Stantec Architecture Inc.
722 12th Street NW Suite 100, Washington DC 20005-3957

October 21, 2022

Reference: New Mexico Proton Advanced Cancer Therapy (NMPACT)
Response to Development Review Board Comments
Project: PR-2022-007588
Application: SI-2022-01658

Title
DRB SITE PLAN

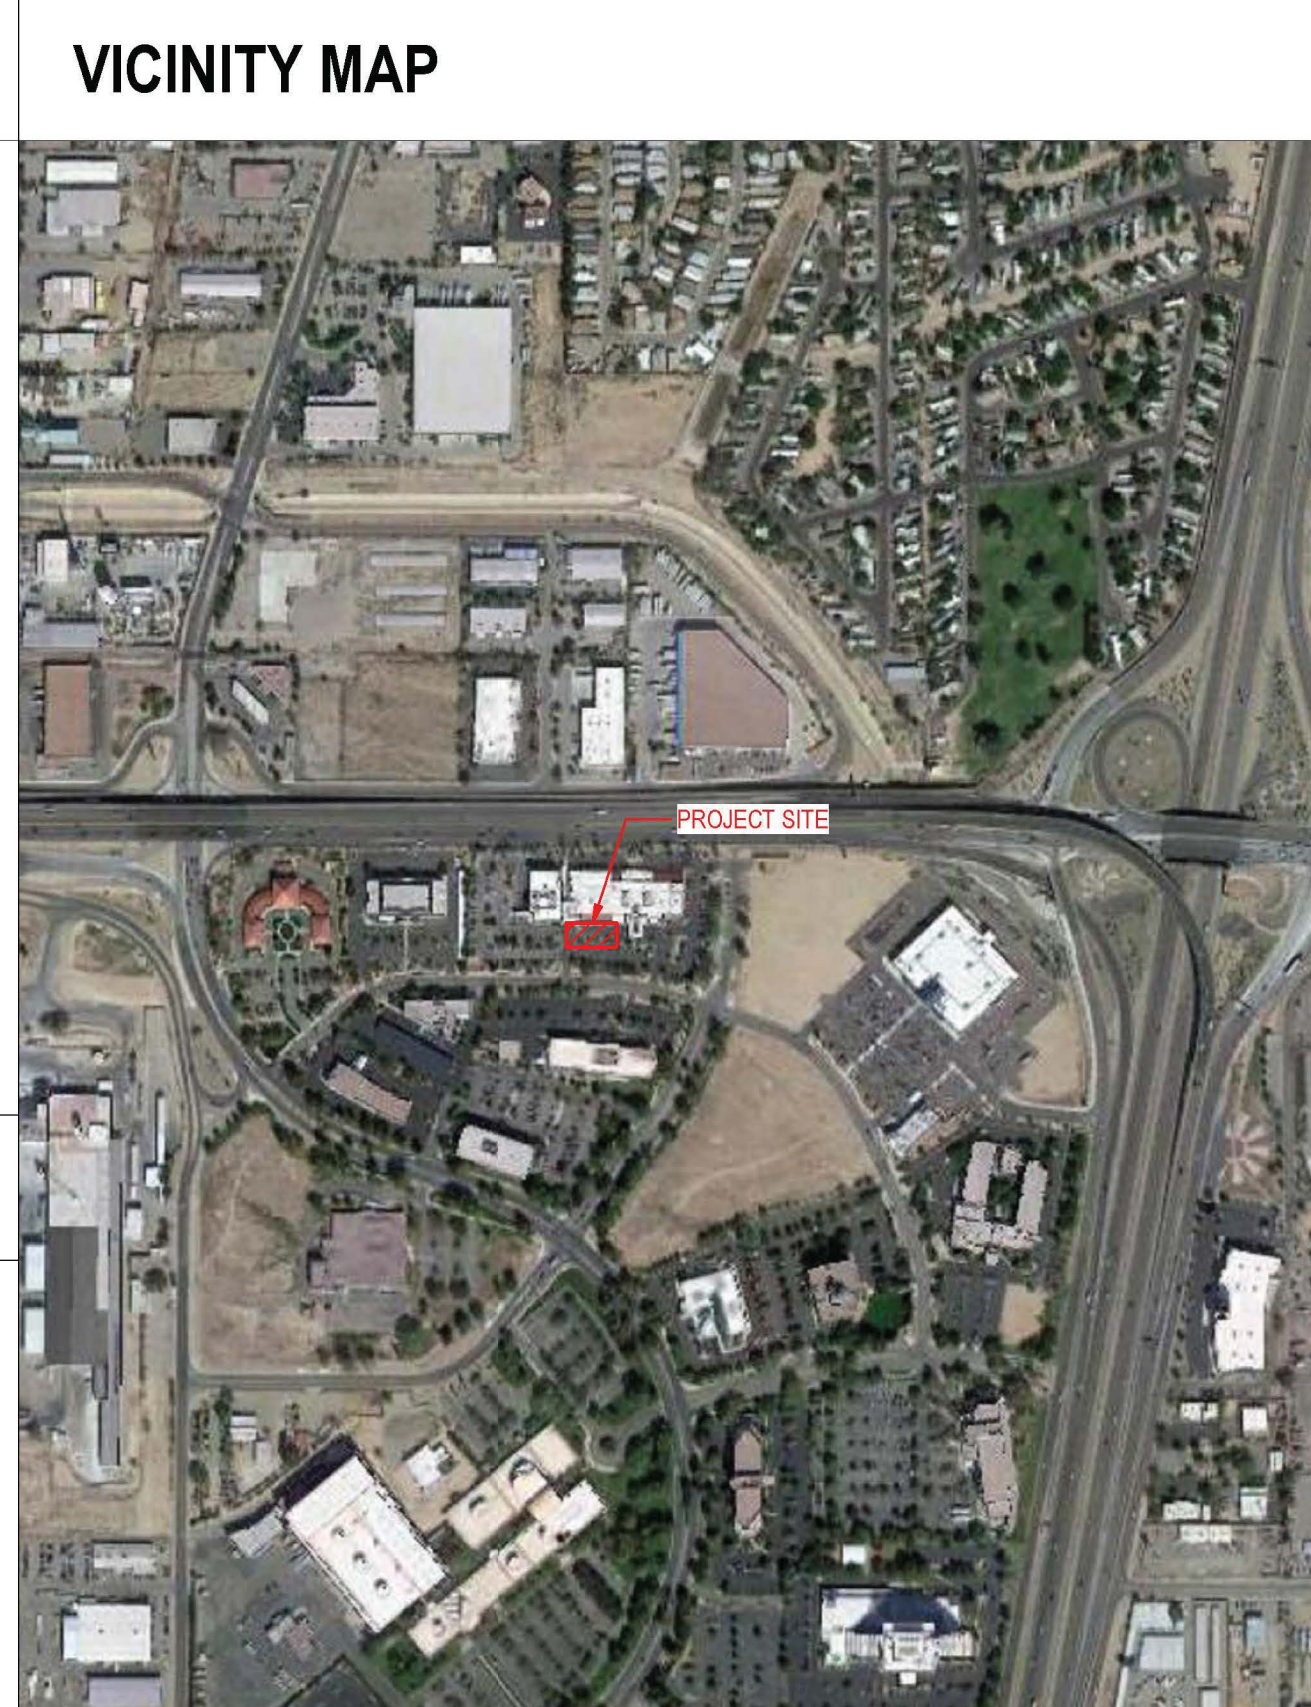
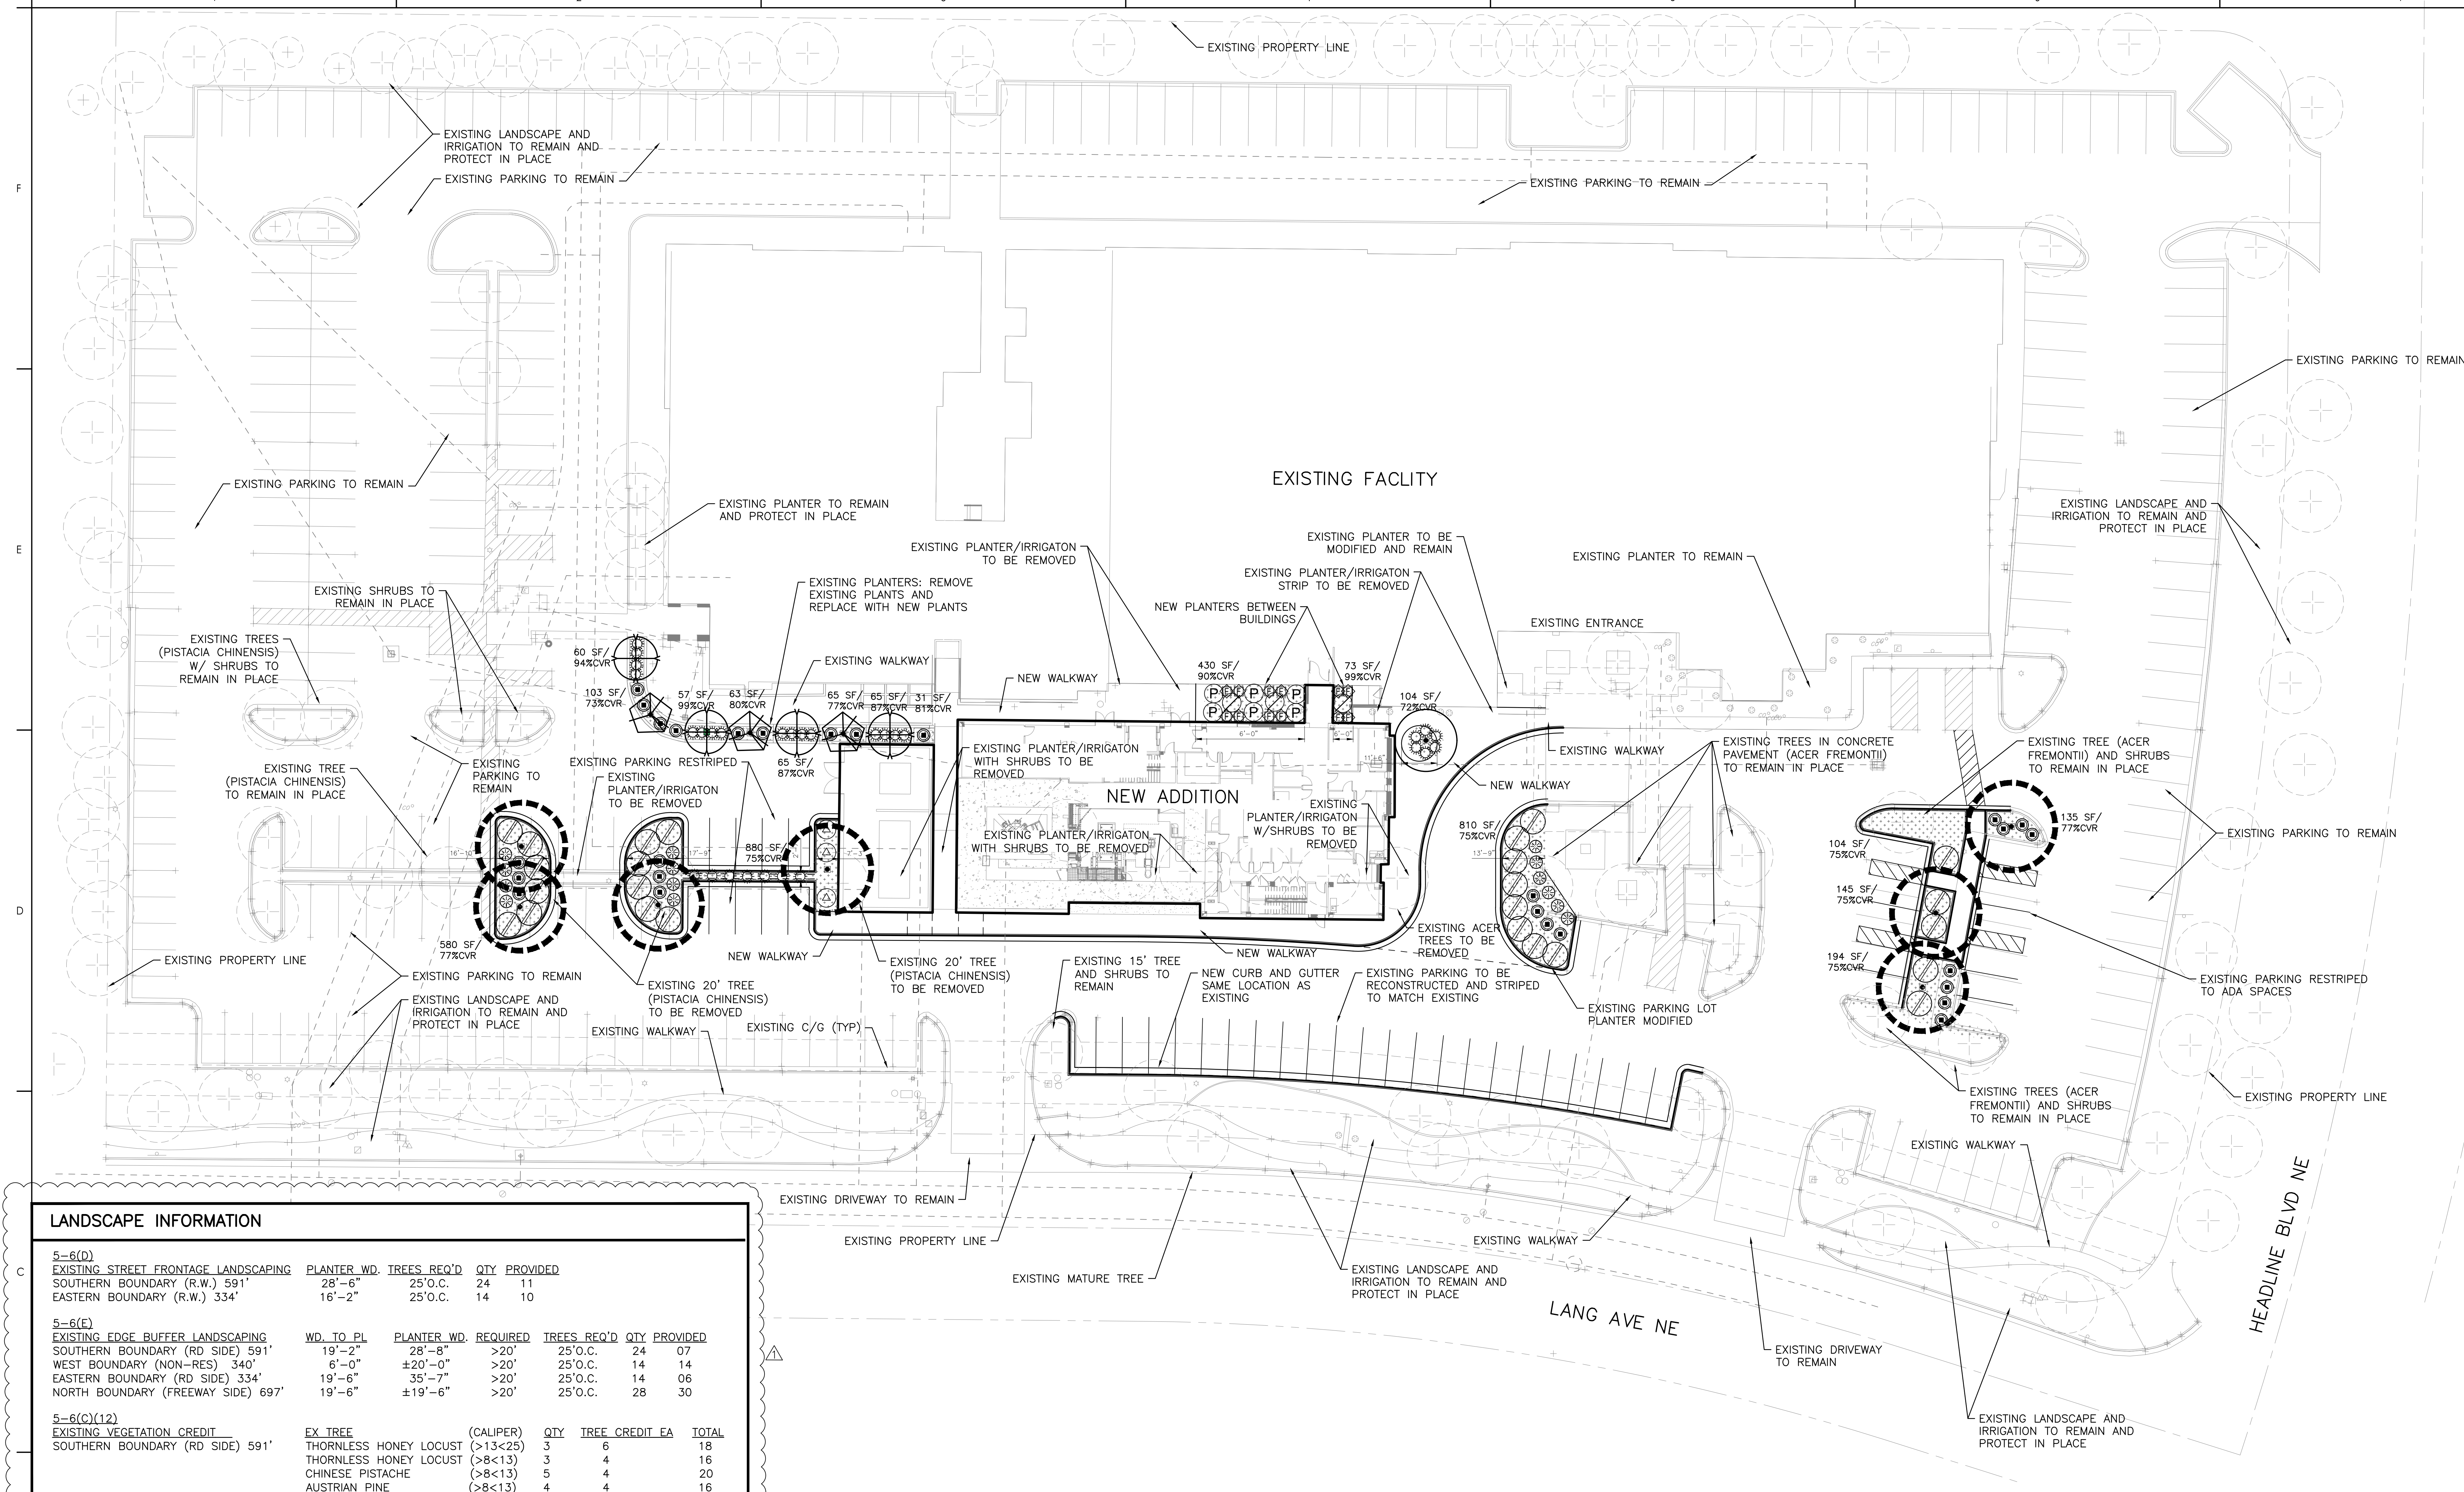
- a. *Stantec Response: Sheet C-102, Solid Waste Plan has been approved. See attached.*
6. The Parking Tabulation section of the Site Plan notes that the parking requirements for the site are based on the previously approved site plan plus the addition at current parking rates. The overall indication is that there is potentially a parking shortage per IDO requirements. Staff has talked to the applicant about sections of the IDO where parking reductions could apply and awaits a resubmittal on parking for the site.

It does not appear #a and #b above have been addressed. These are required for a final determination on the parking study. Could not locate Sheet A1-101 which was supposed to be in the resubmittal.

- a. *Stantec Response: The Owner understands the requirement and will record a Shared Parking Agreement.*
8. The number of bicycle parking spaces which are required are depicted in the Parking Tabulation section, but the number of bicycle spaces/racks which are being provided is not depicted. That information needs to be added to the Site Plan.

9. Detail as to how the required number of motorcycle spaces (6 spaces) was calculated needs to be provided in the Parking Tabulation section.
 - a. *Stantec Response: Sheet C-101, Site Plan has been updated with the required information. See attached.*

10. **Update 10.18.22** Please clearly note the location of bicycle and motorcycle parking spaced on the site plan.
 - a. *Stantec Response: Sheet C-101, Site Plan has been updated with the required information. See attached.*

- i. *Stantec Response: NMCC has prepared a letter (with exhibits) explaining occupancy and lease duration. The letter is attached.*
7. The Parking Tabulation section of the Site Plan notes that 100 parking spaces will be provided off-site. If any off-site parking spaces will be utilized and will count toward the total of number of required parking spaces, a recorded Shared Parking Agreement will be required for those parking spaces and must be submitted prior to the approval of this Major Site Plan Amendment – DRB.

- a. *Stantec Response: Sheet C-101, Site Plan has been updated with the required information. See attached.*

1 TREE PLANTING

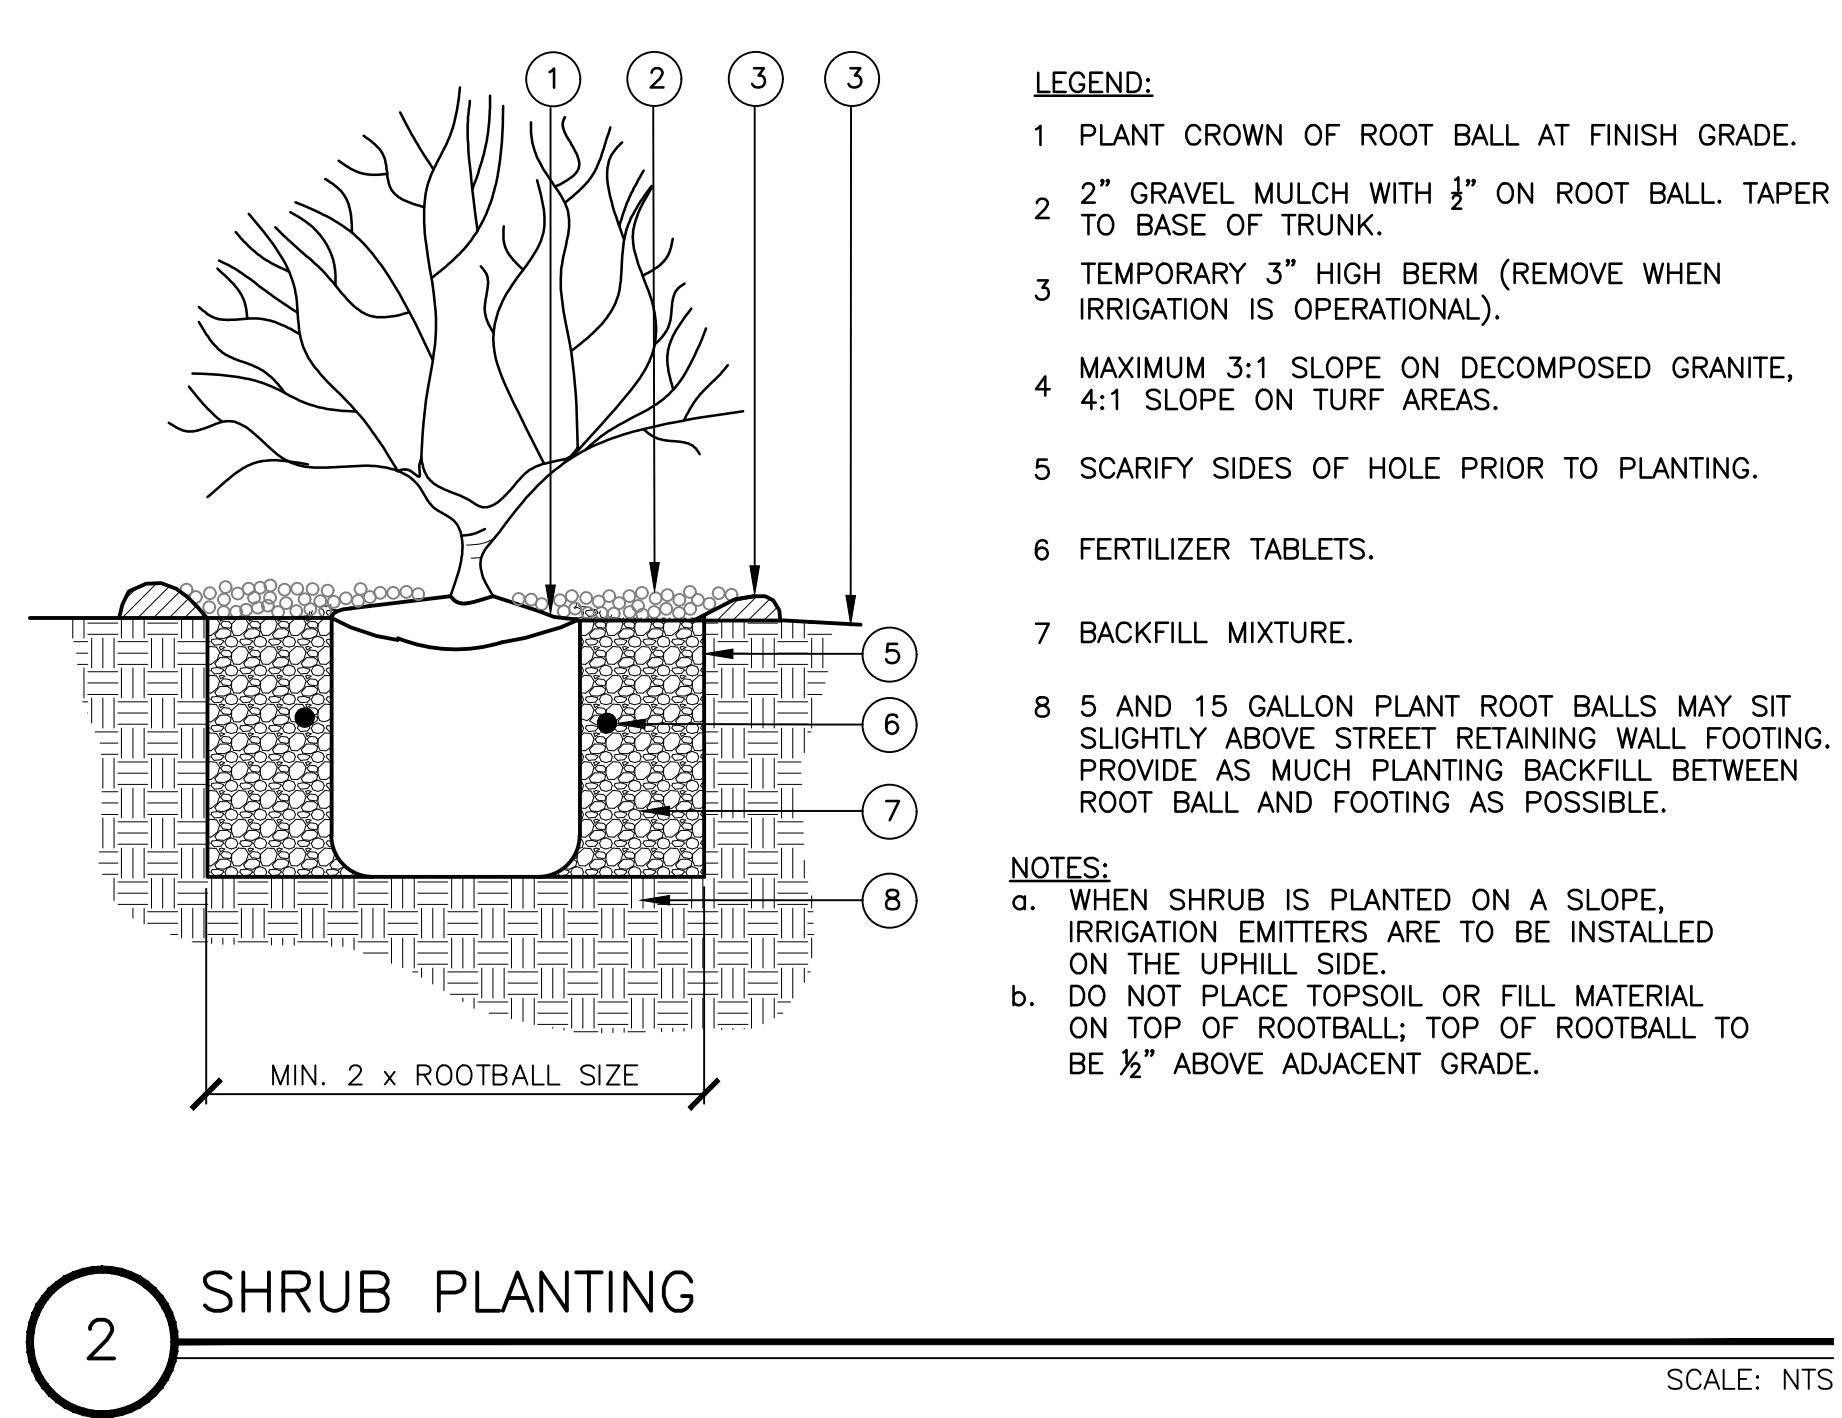
1. Please add note to tree planting detail pursuant to IDO 5-6(C)(5)(e): “Organic mulch is required as ground cover under trees within a 5-foot radius around the tree trunk, but not directly against the trunk. In these areas, weed barrier fabric is prohibited.”
 - a. *Stantec Response: Sheet C-701, Landscape – Landscape Plan has been updated to include the note; reference Detail 1. See attached.*
